Ribble Valley Borough Council
Housing & Development Control

Your ref: 3/2023/0866
Our ref: D3.2023.0866
Date: 22nd April 2024

Address: **Land adjacent to no 9 Old Road Chatburn BB7 4AB**

Proposal: **Proposed five-bedroom, two-storey dwelling with a room in the roofspace.**

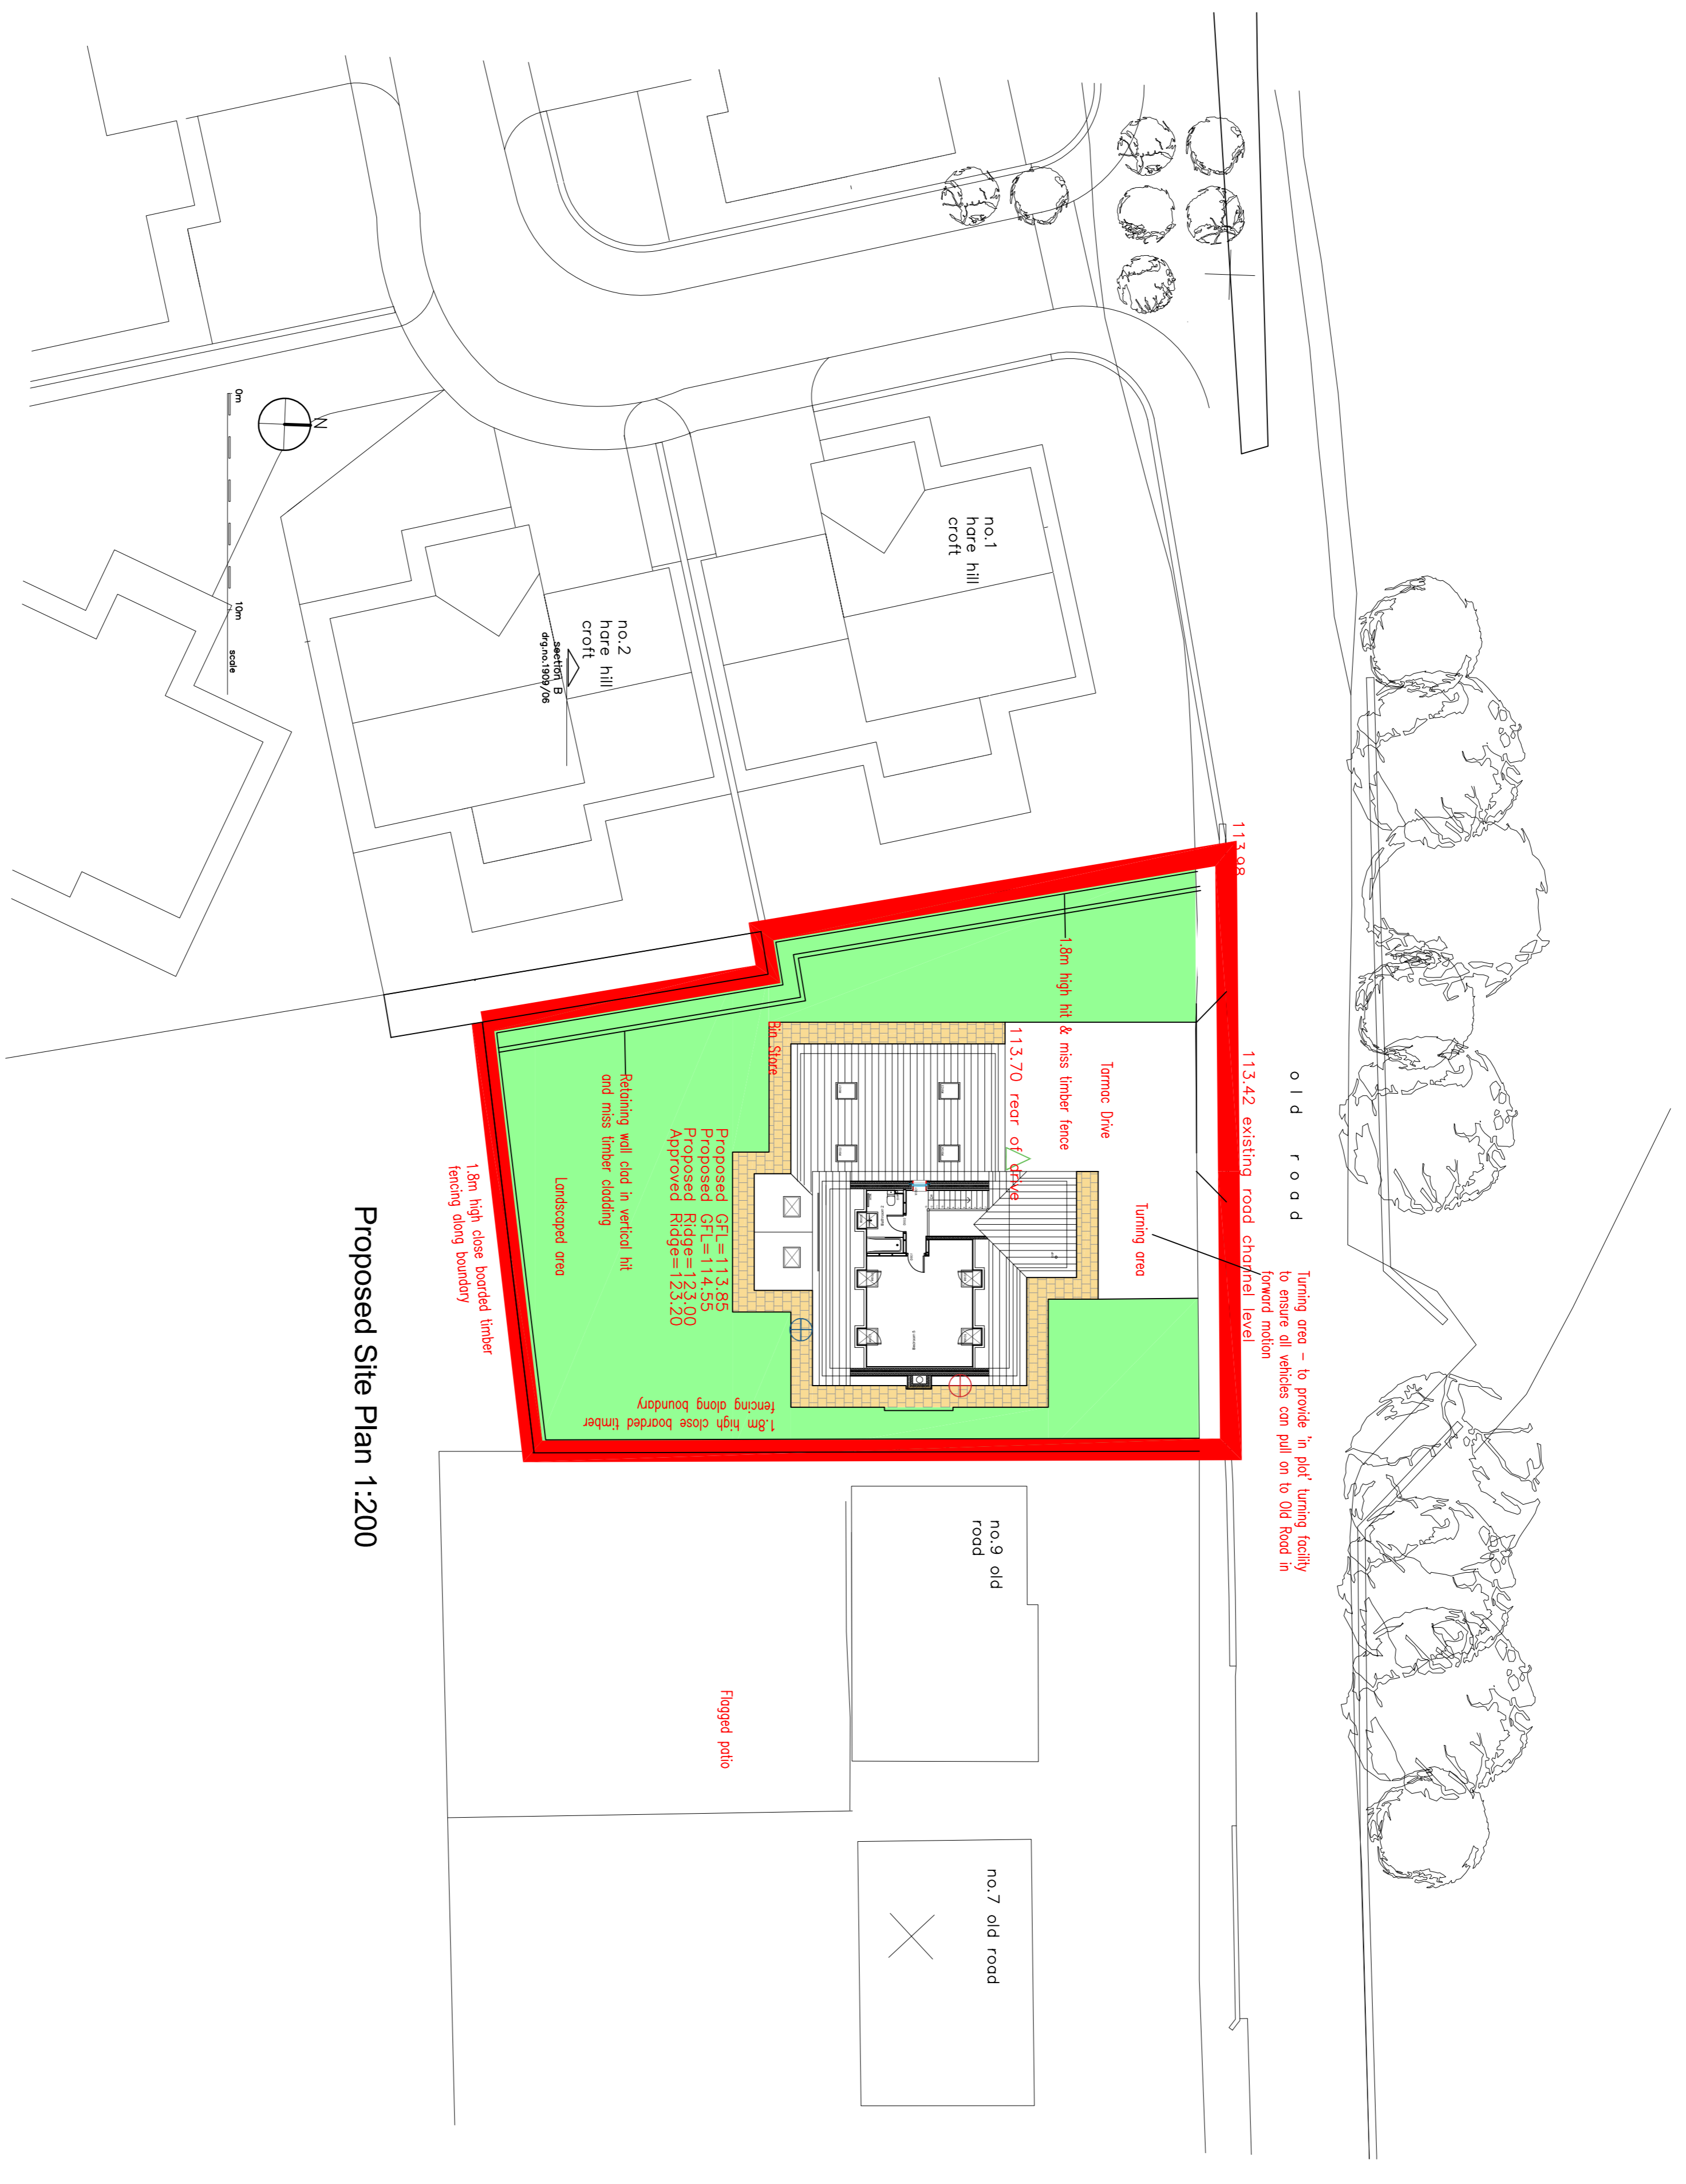
The LHA have reviewed drawing number COR/Plot 11/SPVS titled "Housetype Substitution Site Plan with visibility splay" and consider this acceptable.

The LHA have reviewed drawing number COR/Plot 11/SPVS titled "Housetype Substitution Site Plan with visibility splays" and are aware that the parking arrangements complies with the LHAs parking guidance as defined within the Joint Lancashire Structure Plan.

The dwelling will also provide a minimum of one electric vehicle charging point and the LHA will later condition that a minimum of two bike stands are provided in the attached garage.
